Our Ref: 140RF500

19 December 2014

PLANNING APPLICATION REFERENCE 2014/1055
HYBRID PLANNING APPLICATION FOR MIXED-USE DEVELOPMENT
"ROCKINGHAM 1", DEARNE VALLEY PARKWAY, HOYLAND

Following various recent meetings and correspondence regarding the above proposed scheme, please find enclosed (submitted by email) additional material submitted as part of planning application ref. 2014/1055. This letter sets out the material submitted and to be substituted, whilst providing an explanation as to how the amendments made respond to the matters arising in consultation.

Drawing No **4652-R1** D

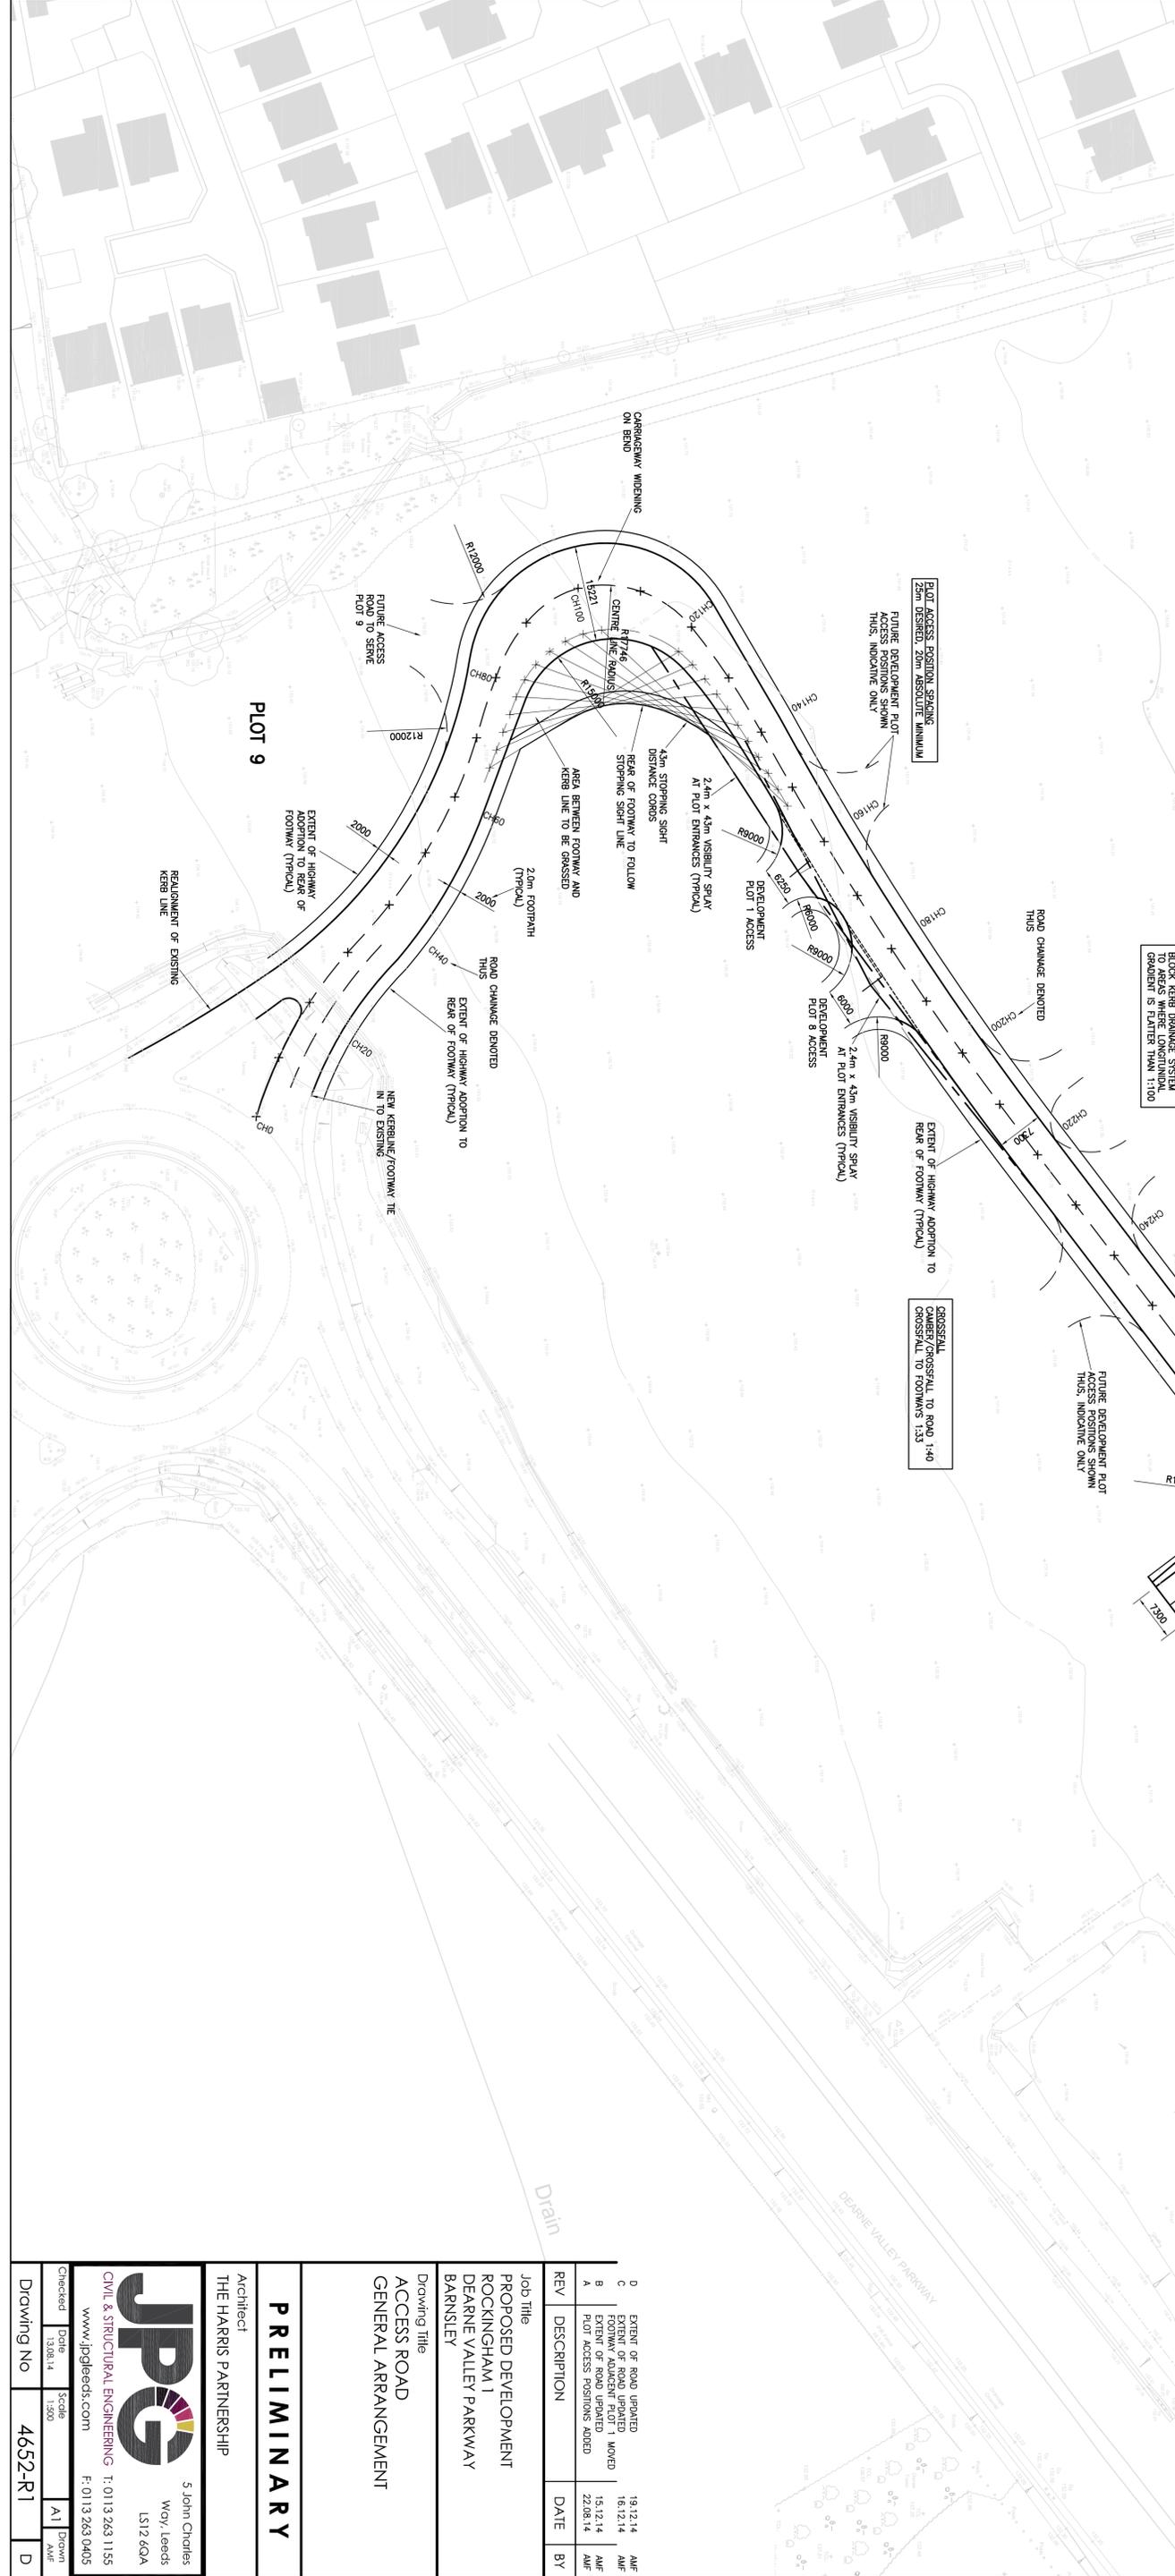
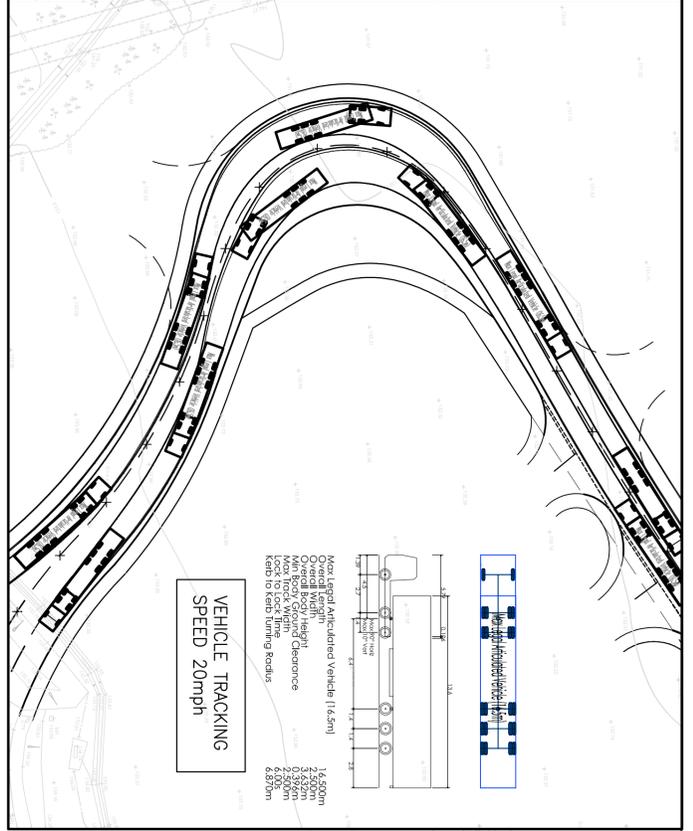
The provision for a roundabout within the site has been omitted following the removal of potential access to land to the north from the southwest of the site. Any potential future access to land to the south may be achieved via a priority junction arrangement (subject to acceptable levels of off-site traffic generation) to the proposed spine road in the same location as the access to plot 9.

The proposed alignment of the spine road has been adjusted slightly in this location to optimise land-use and accommodate forward visibility splays, as shown on the Access Road General Arrangement drawing.

Plot 1 - 0.85 acres (0.34 hectares)
Plot 2 - 1.05 acres (0.42 hectares)
Plot 3 - 1.46 acres (0.59 hectares)
Plot 4 - 1.63 acres (0.66 hectares)
Plot 5 - 1.87 acres (0.75 hectares)
Plot 6 - 1.70 acres (0.53 hectares)
Plot 7 - 1.40 acres (0.56 hectares)
Plot 8 - 1.27 acres (0.51 hectares)

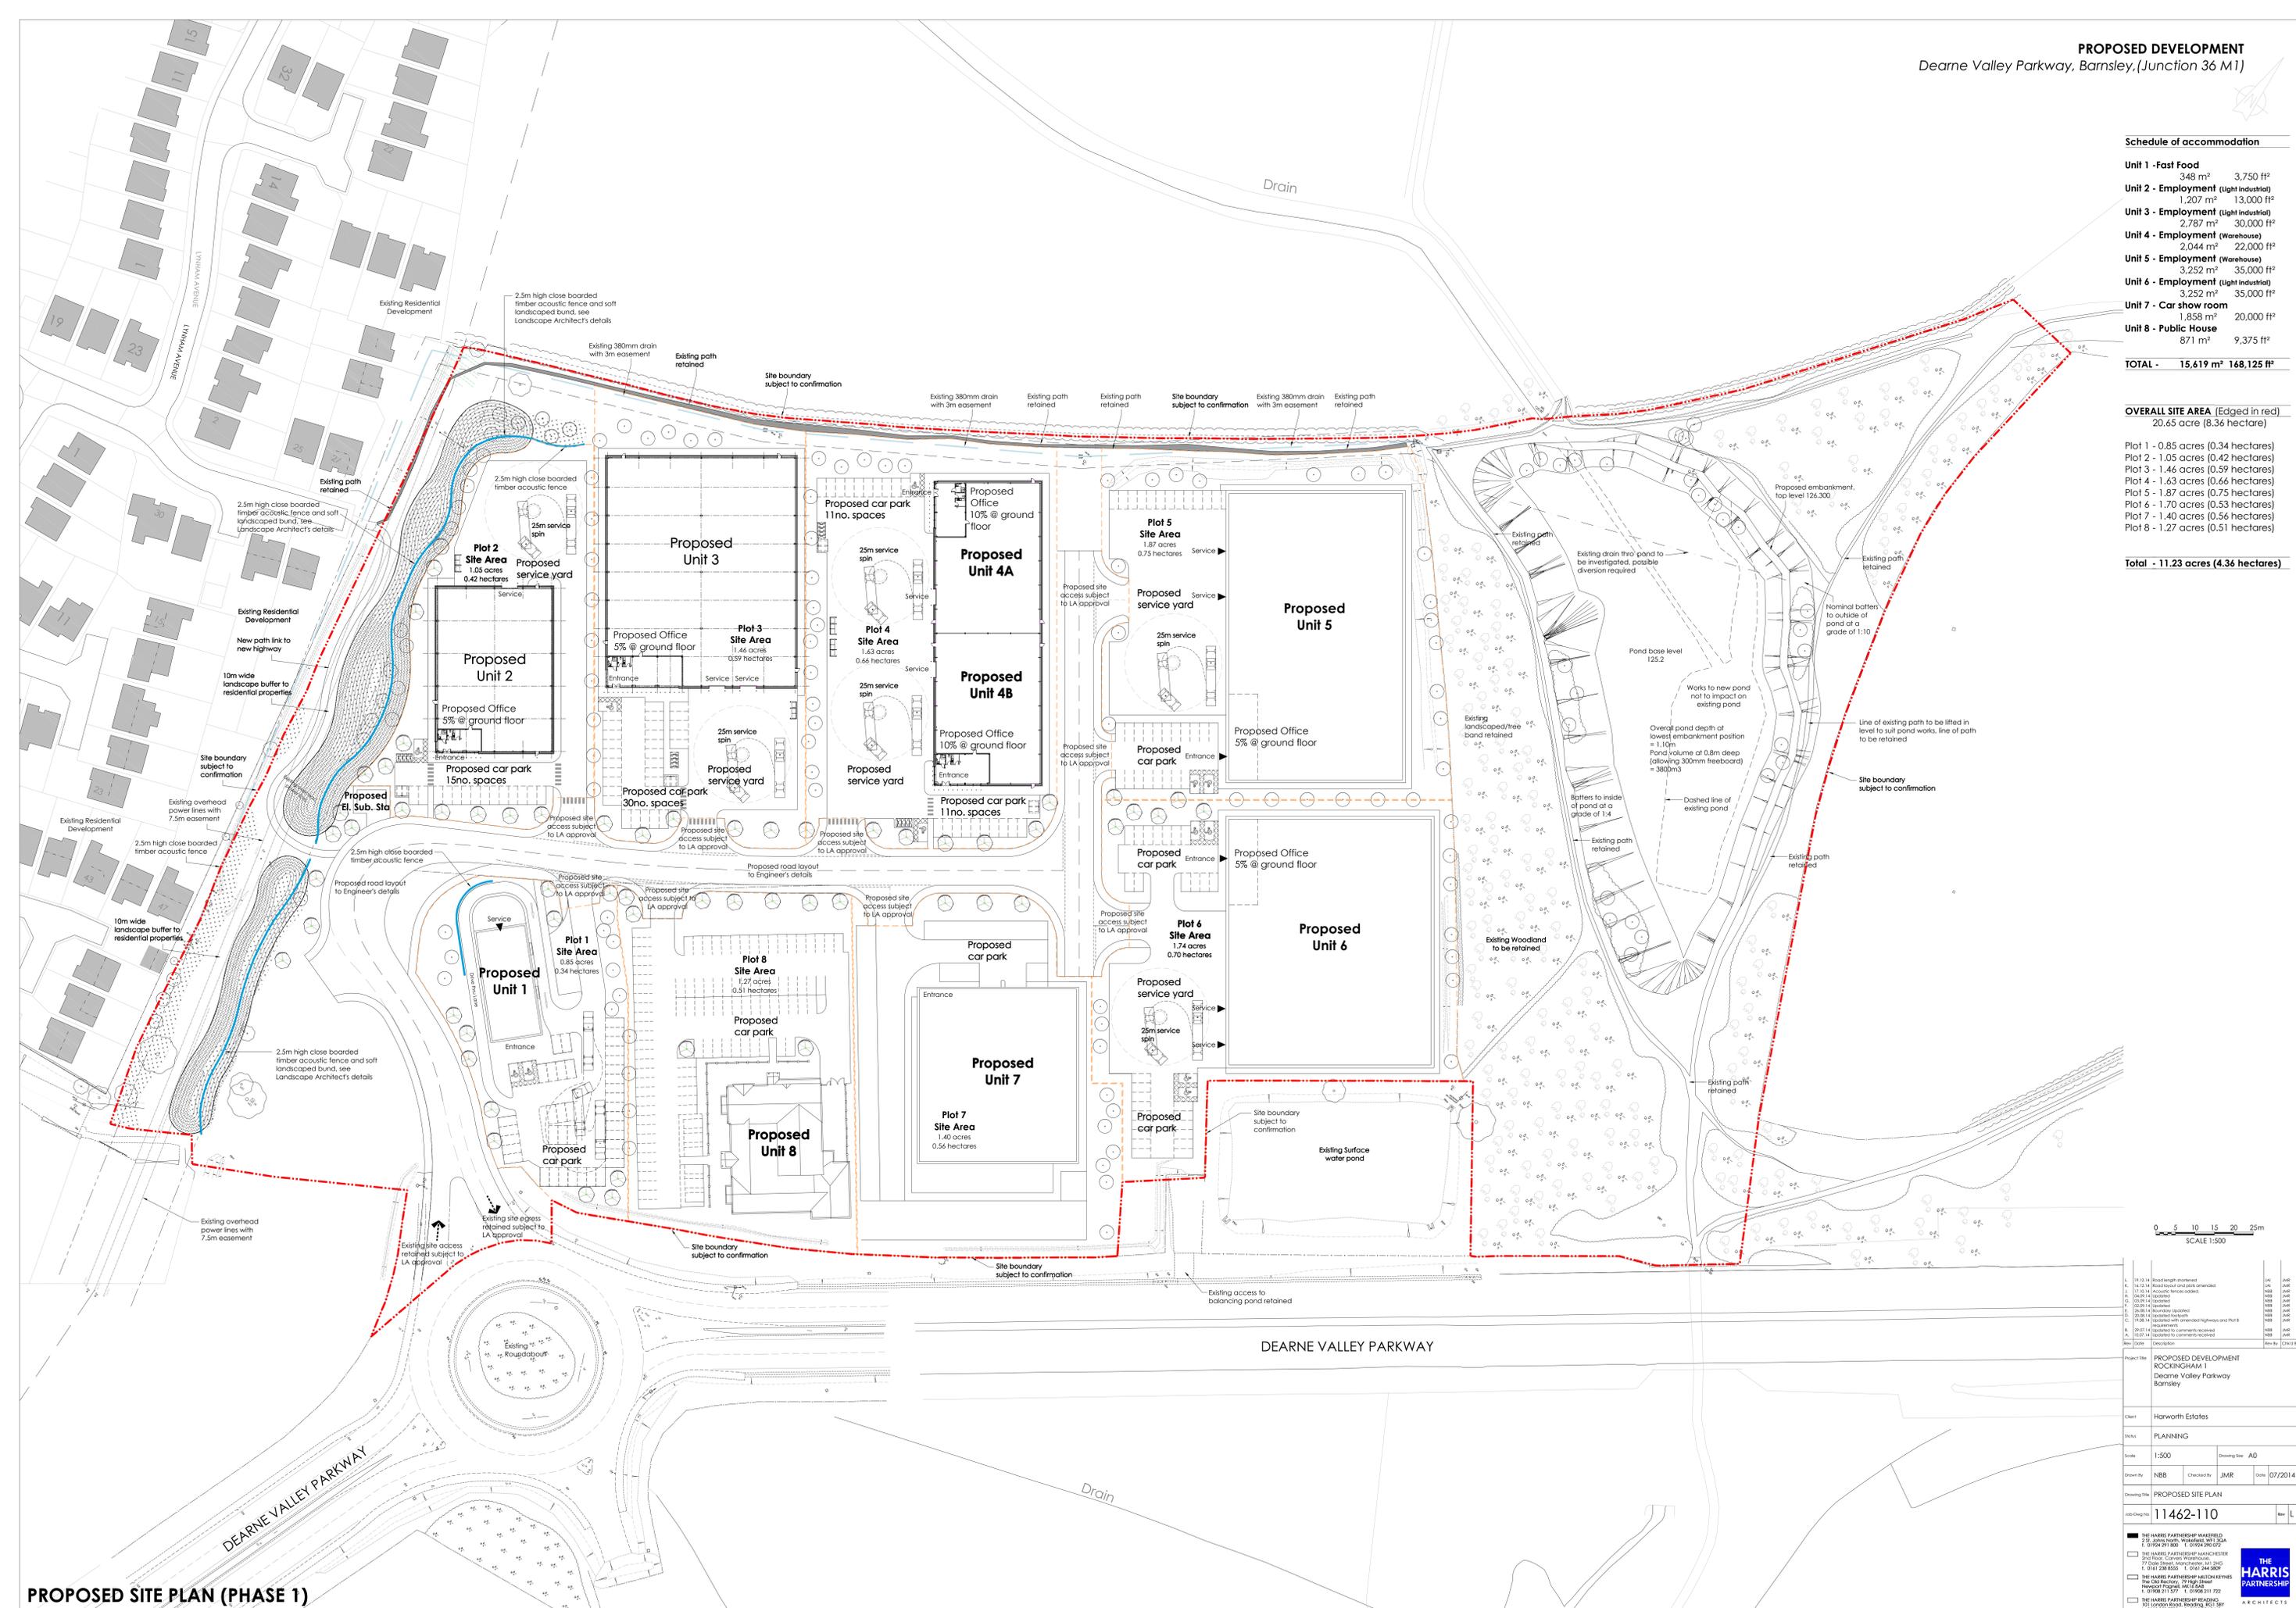
The prospective alignment of any access road to the south has been amended to increase its distance from the residential boundary as shown on the illustrative masterplan. The effect of this is to increase the area for buffer landscaping.

The grass strip between plot 2 of the development and the residential boundary, which served to maintain provision for a possible future vehicular access to land to the north, has now been removed from the proposed scheme. Any such access will now be taken between plots 4 and 5 within the centre of the development site as shown on the illustrative masterplan. The effect of this is to reposition plots 2, 3 and 4 slightly to the southwest of their original position, whilst still retaining a strip for buffer landscaping. There will therefore be no prospect of vehicle movements adjacent to the residential boundary, which will provide a long term amenity benefit.

Informal footpath provision is maintained to the west and north boundaries of the development site. The illustrative masterplan also increases pedestrian permeability by creating a new route from land to the north, via the spine and spur roads, to the site's main access point. Subject to separate approvals, this new alignment will accommodate the public right of way which crosses the site.
